Our Reference: SYD13/00320
Your Reference: MP10_0230
Contact: James Hall
Telephone: 8849-2047

Transport
Roads & Maritime
Services

EXHIBITION OF WOOLLOOWARE BAY TOWN CENTRE - STAGE 1

TYPICAL SECTION - CAPTAIN COOK DRIVE

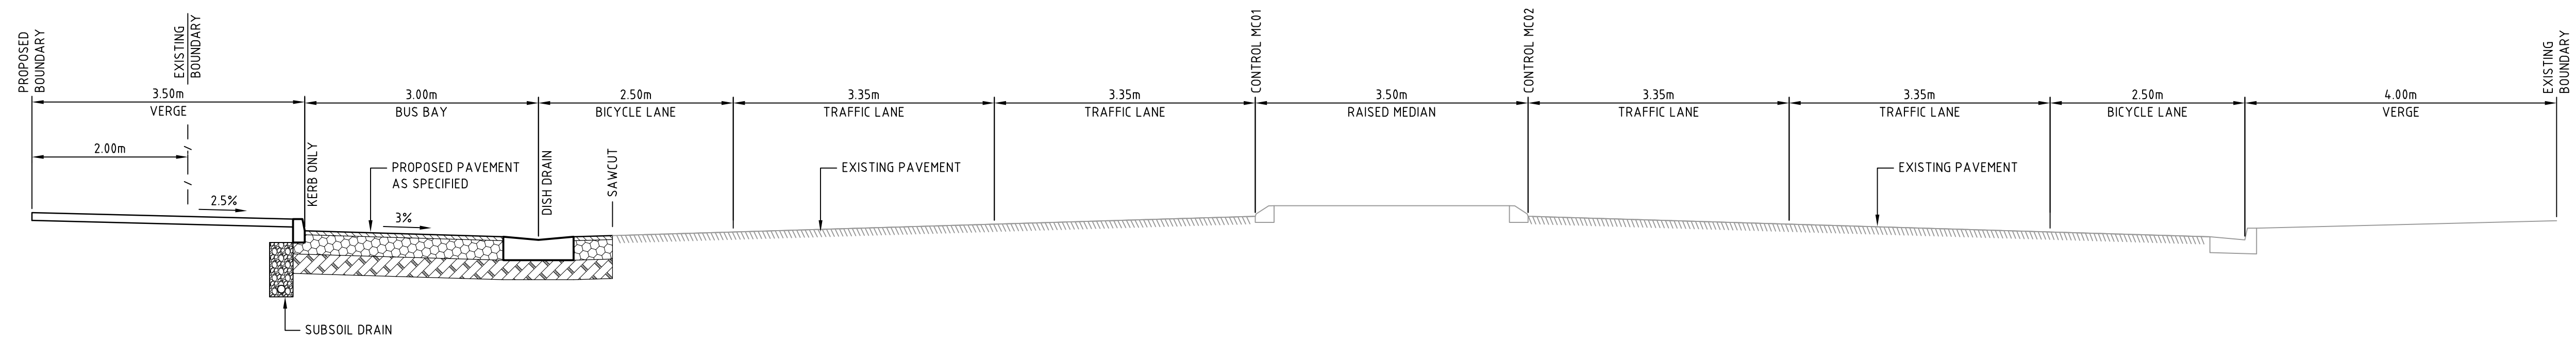
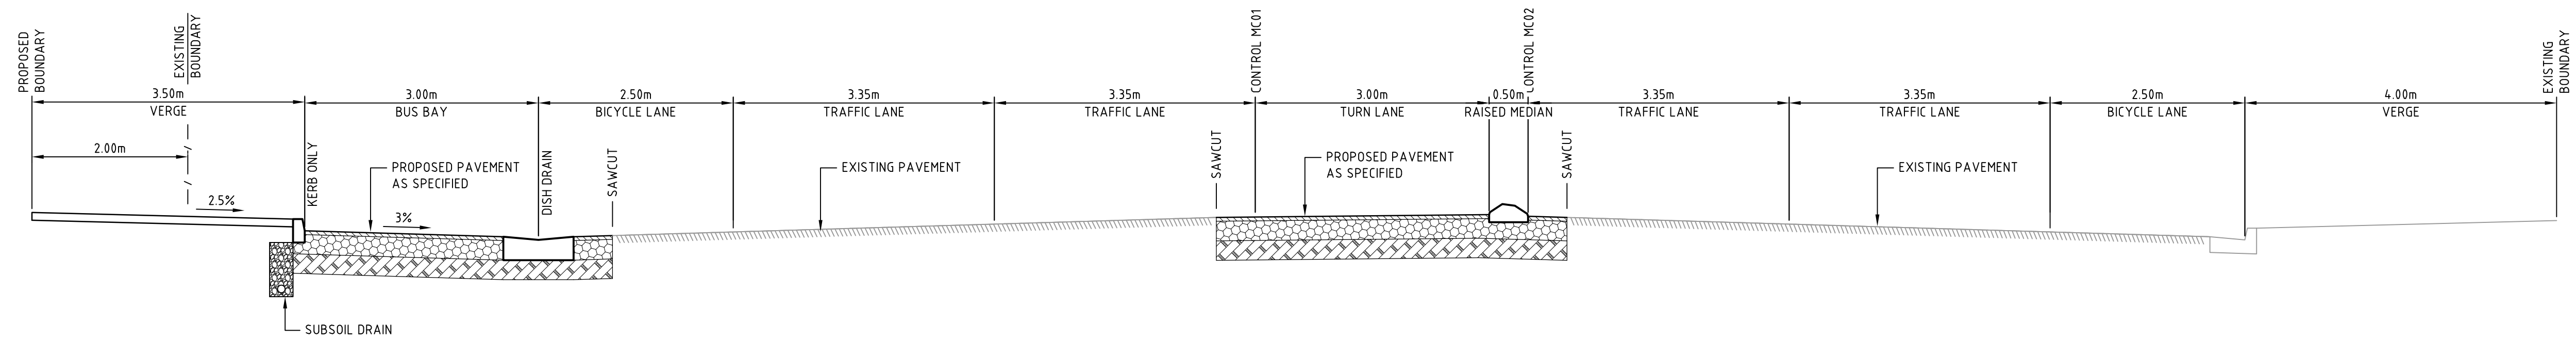
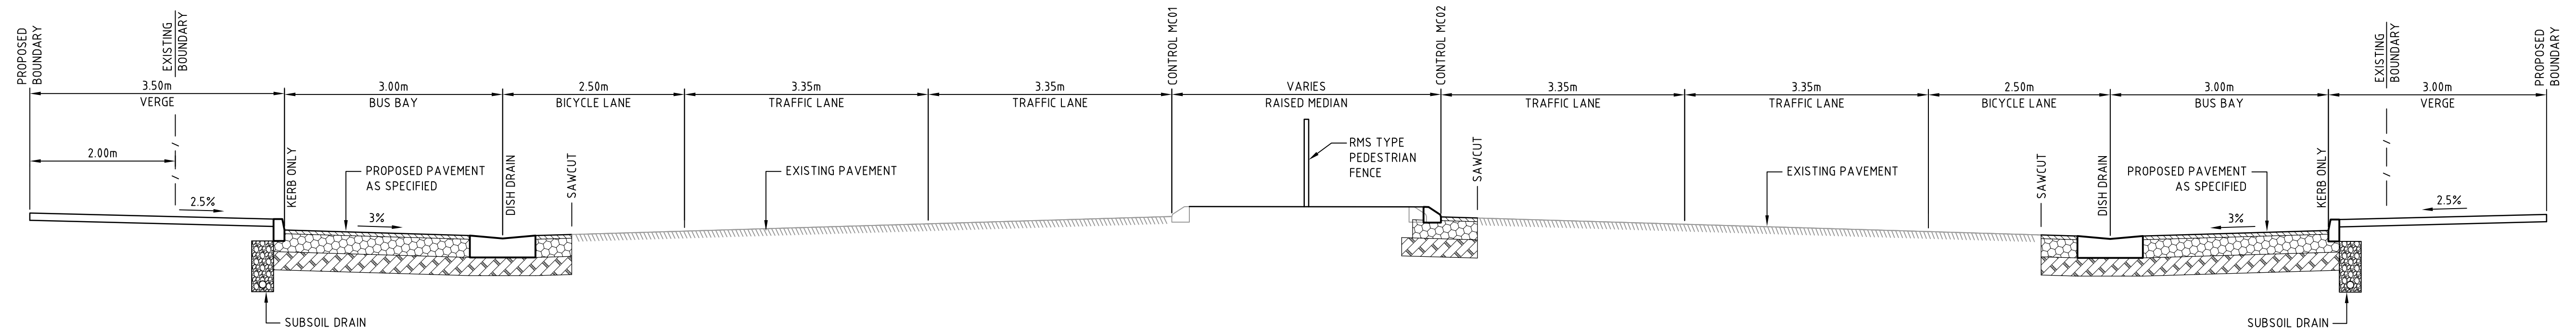
1. The proposed signalised intersections on Captain Cook Drive shall be designed and constructed to RMS requirements.

In this regard, the signal phasing and geometric layout of the signalised intersections shall be as depicted in the SCATES modelling submitted in an email dated 14 December 2012 to RMS from McLaren Traffic Engineering Pty Ltd and the civil design plans prepared by at&I dated 29 January 2013.

4. Whether or not a marked foot crossing is provided across the signalised entrance to a private development, there must be a level separation between the road and footpath through the construction of a barrier kerb and gutter. Kerb ramps must be provided in accordance with RMS requirements.

6. In accordance with RMS's Technical Direction for new traffic signals, signalised pedestrian crossings shall be provided on all legs of the proposed signalised intersections.

TYPICAL SECTION - WOOLLOOMARE ROAD NORTH

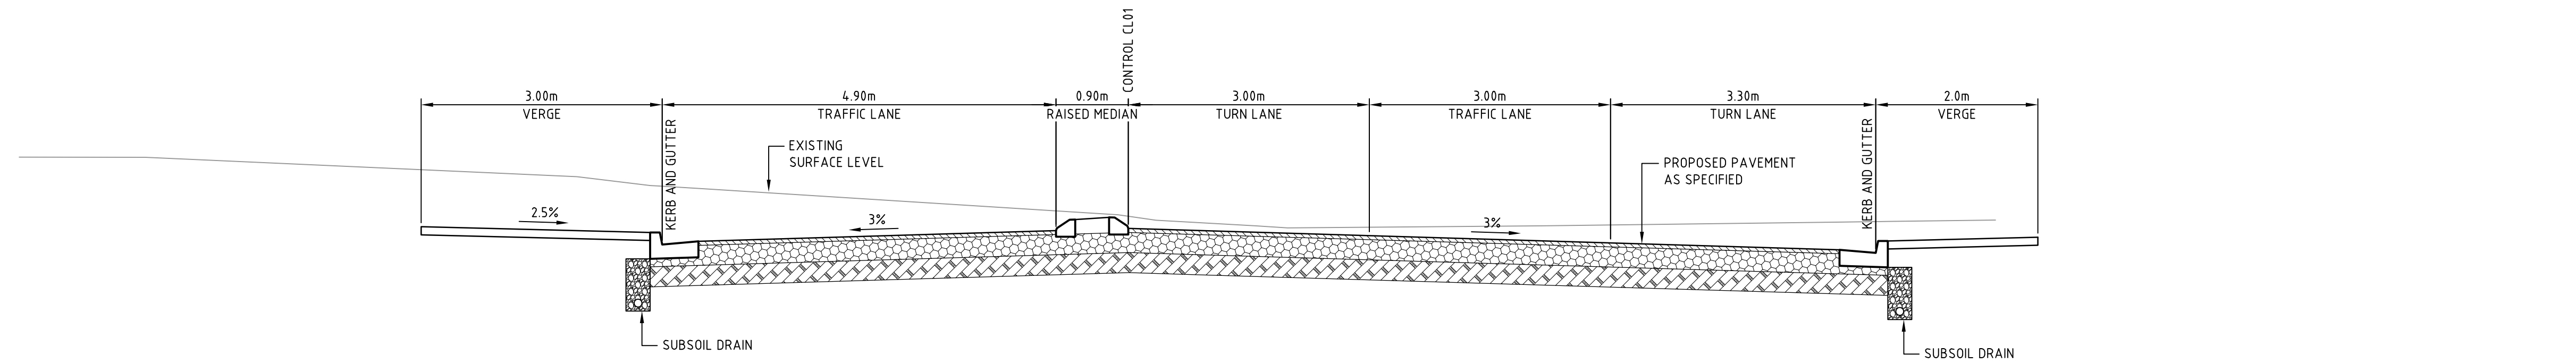
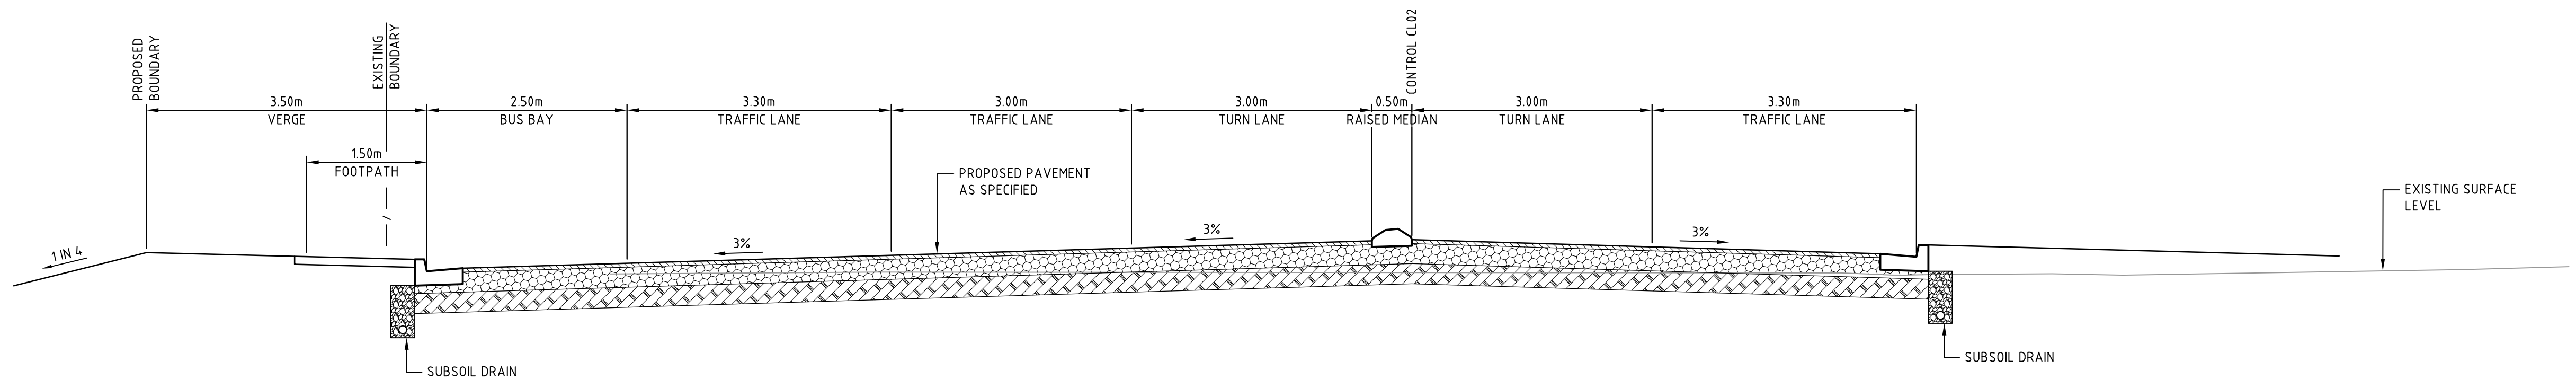
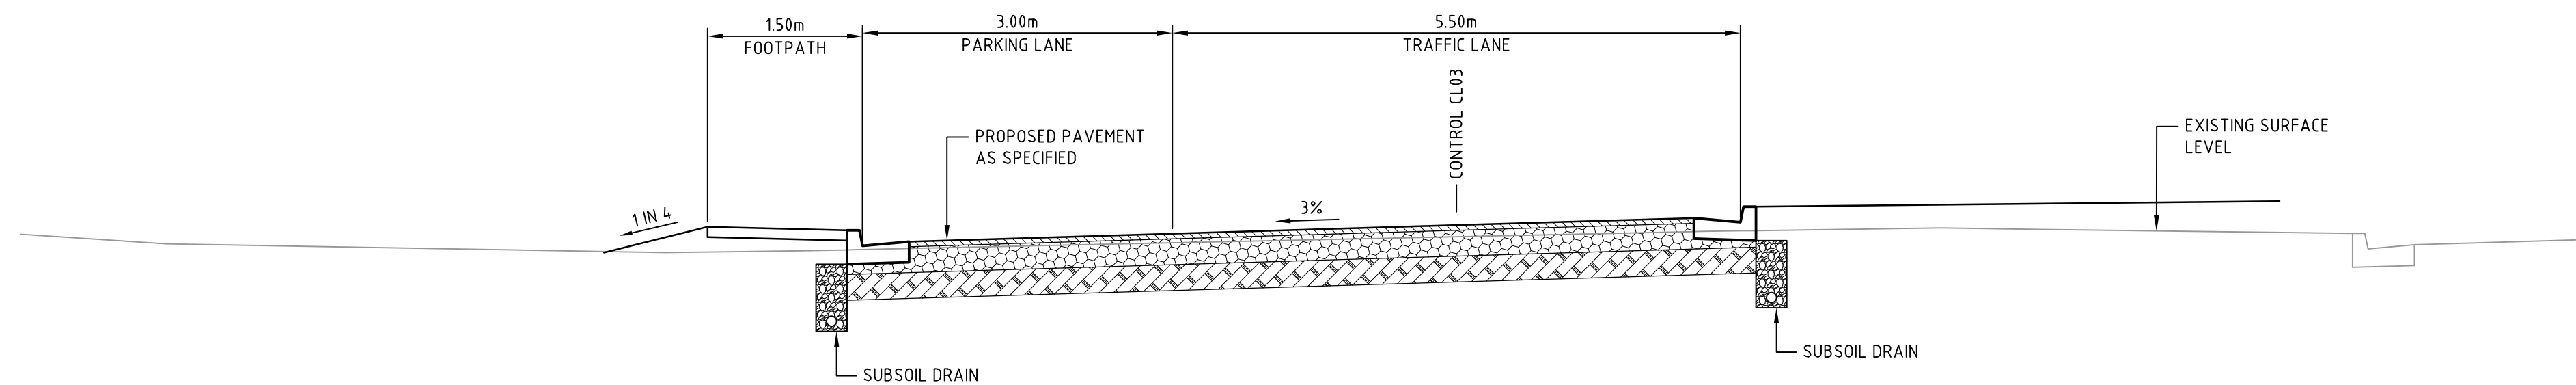
16. Due to the proximity of the proposed retail car park driveway on Woollooware Road North to the proposed signalised intersection on Captain Cook Drive, this driveway should be restricted to left in/left out movements only. Right turn movements at this driveway should be prohibited by extending the proposed central raised concrete median island on Woollooware Road North from the stop line at the proposed signalised intersection on Captain Cook Drive to an appropriate distance past the proposed driveway. Vehicles exiting the proposed retail car park onto Woollooware Road North can utilise the cul-de-sac at the end of this road to access the signalised intersection on Captain Cook Drive.

INTERSECTION CAPTAIN COOK DRIVE AND PROPOSED LOADING DOCK
19.0m SEMI TRAILER AND 12.5m BUS TURN PATH PLAN

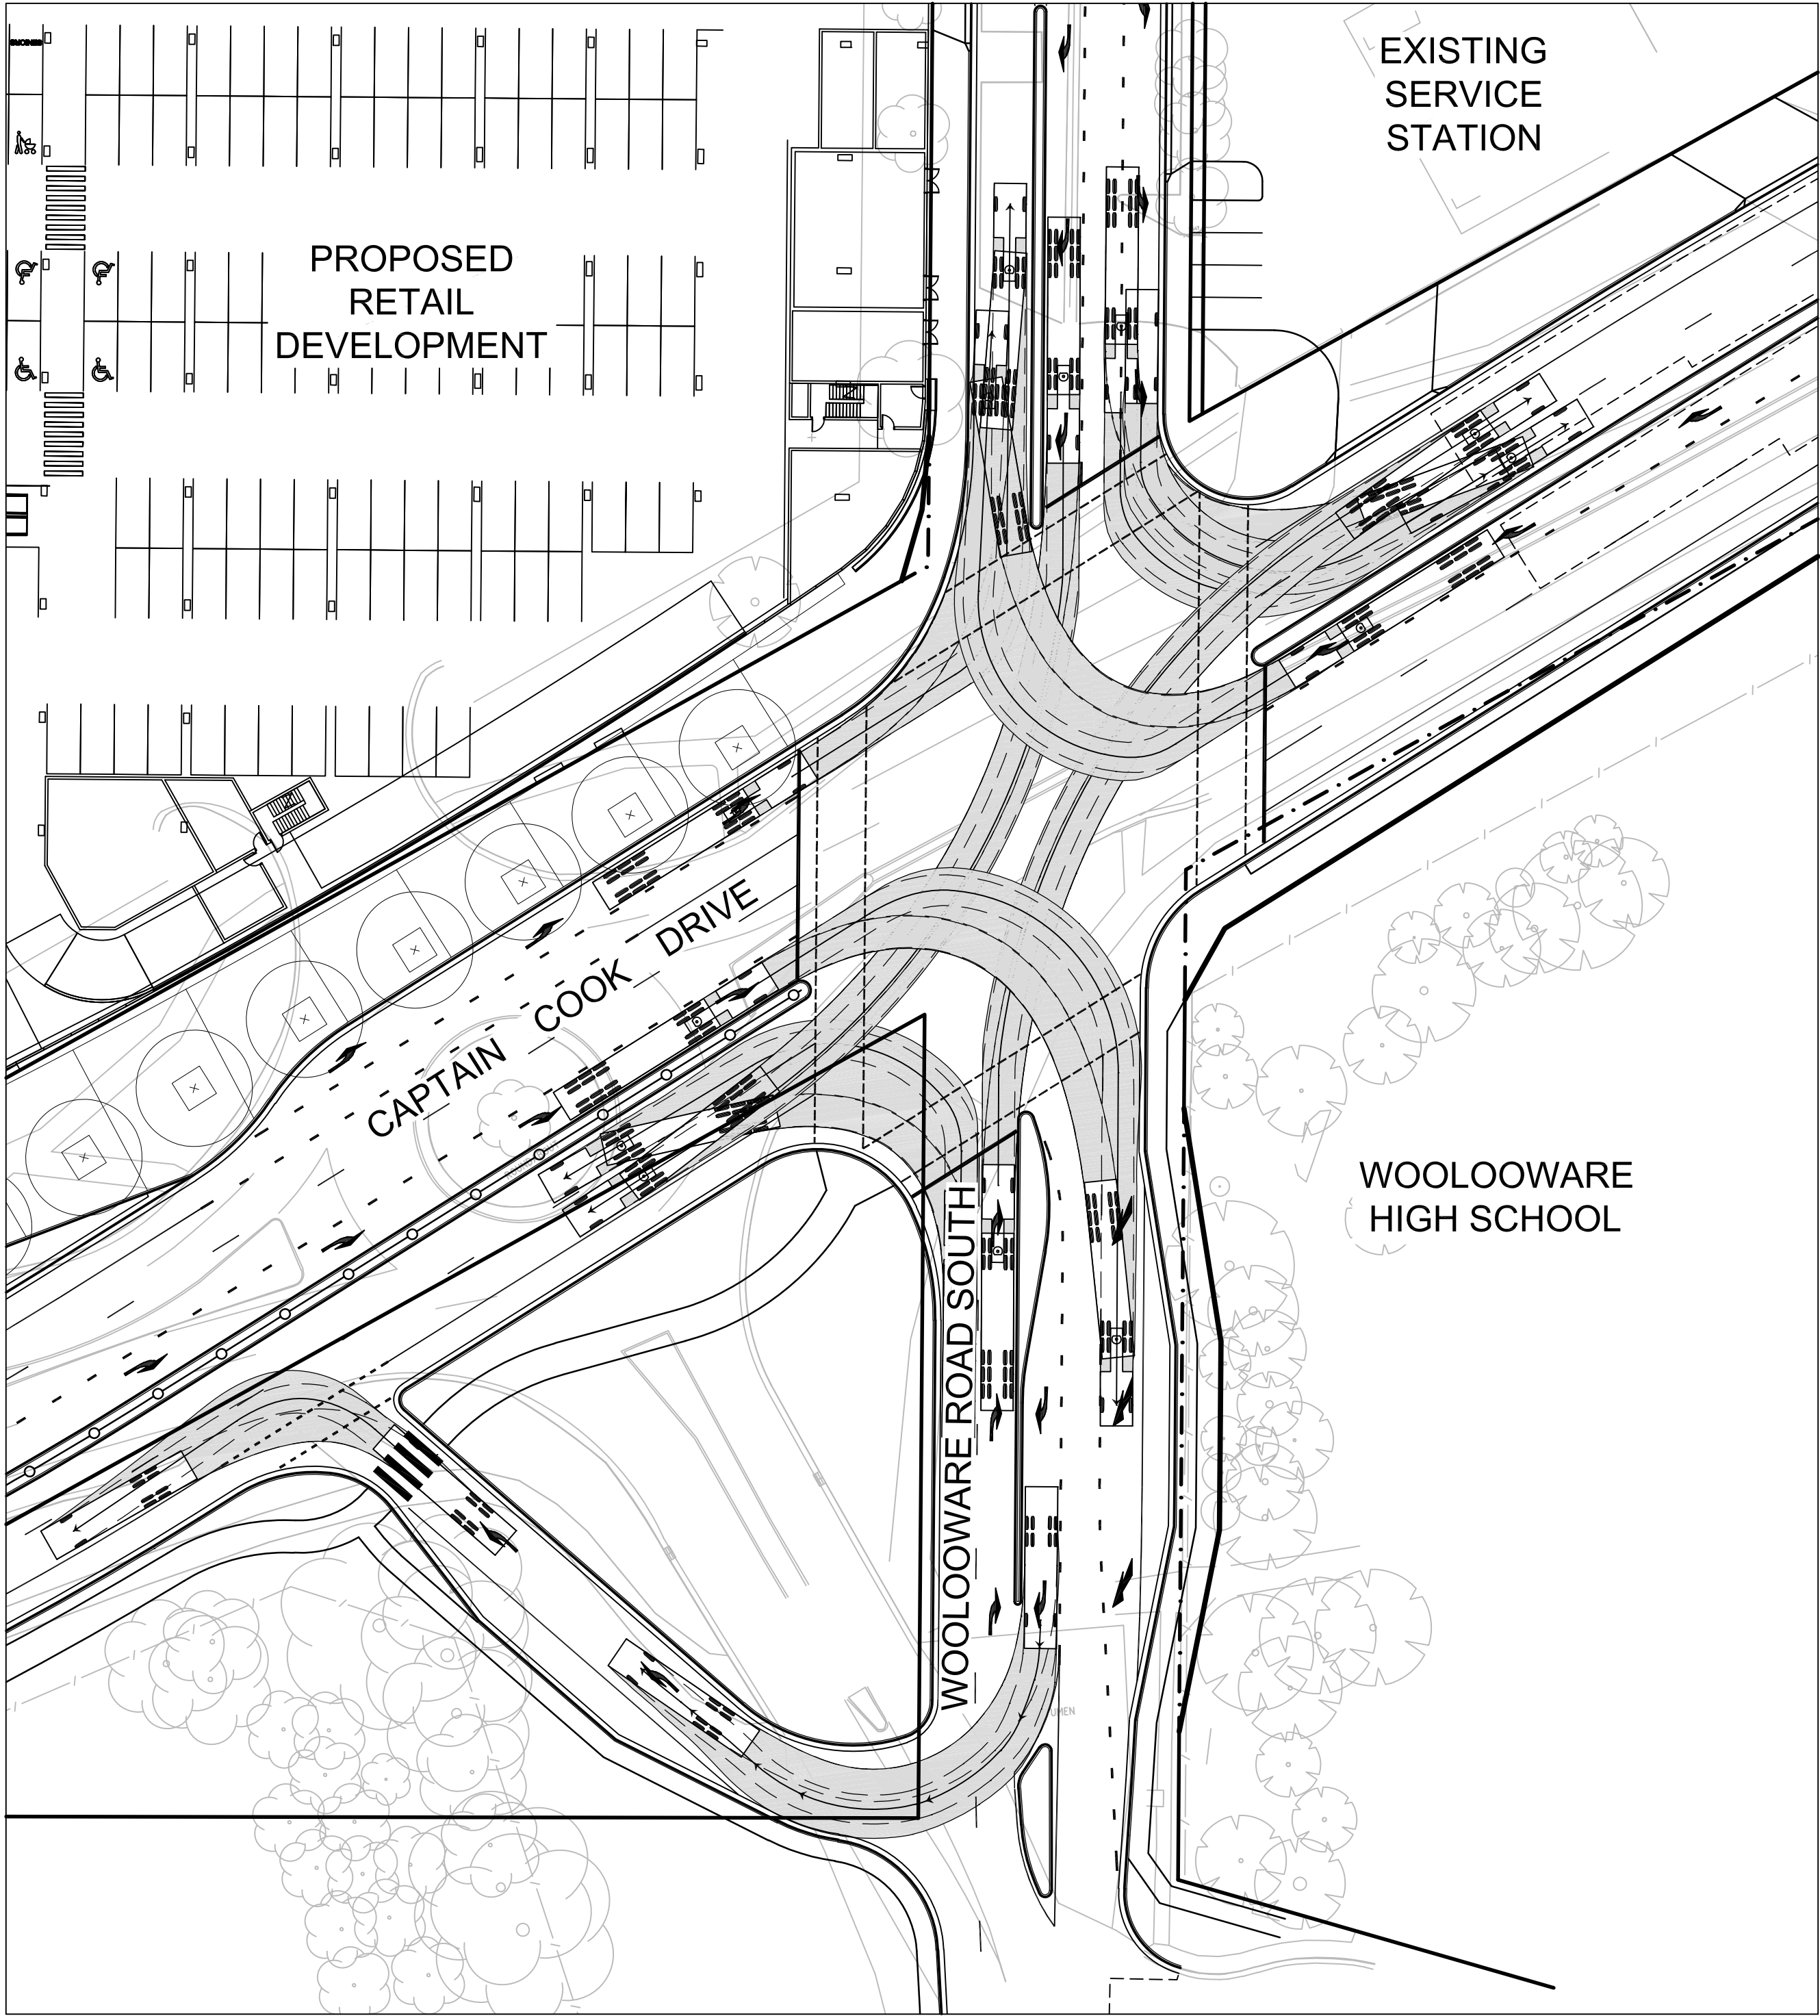
17. The swept path of the longest vehicle entering and exiting the subject site, as well as manoeuvrability through the site, shall be in accordance with Austroads.
